Conservation Area Advisory Committee

Meeting Date : 3 August 2015

AL/74/15/TC Fell 1 No. Holly tree within St Mary's Church
the Church Road Aldingbourne Church Road
Conservation Area Aldingbourne

Plan for Tree Work in Conservation Area

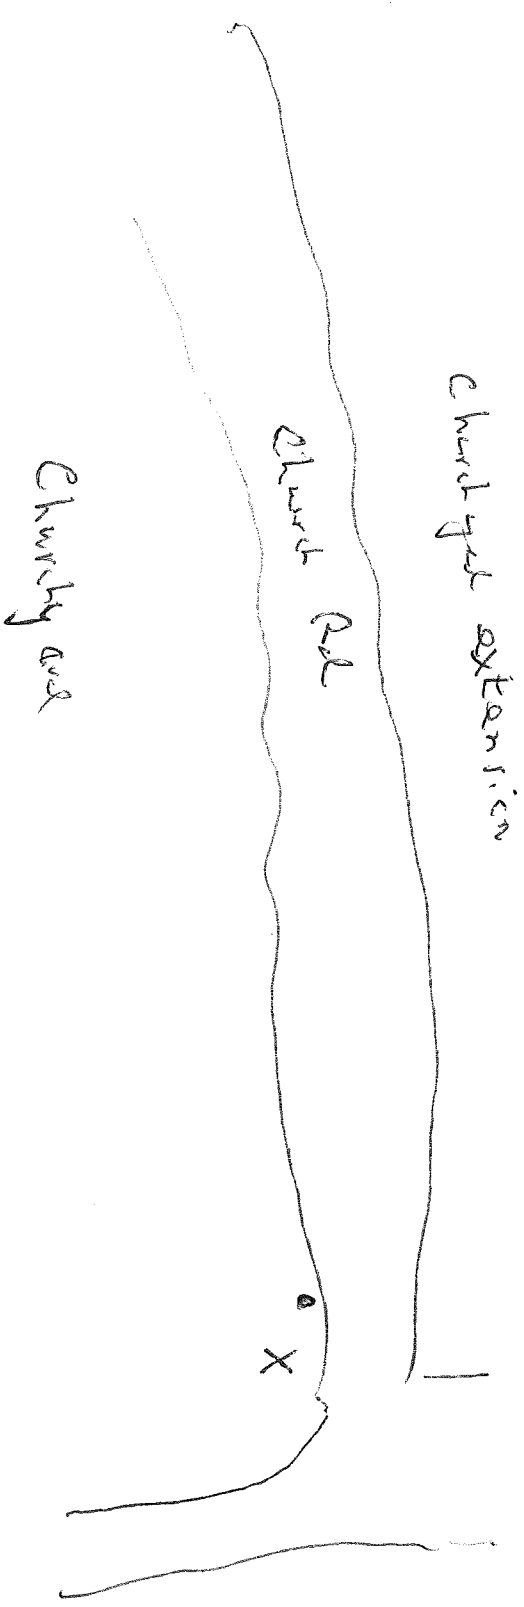
Regret loss of tree - refer to Tree map
Suggest a replacement tree be planted in an
alternative position if it is found necessary to fell
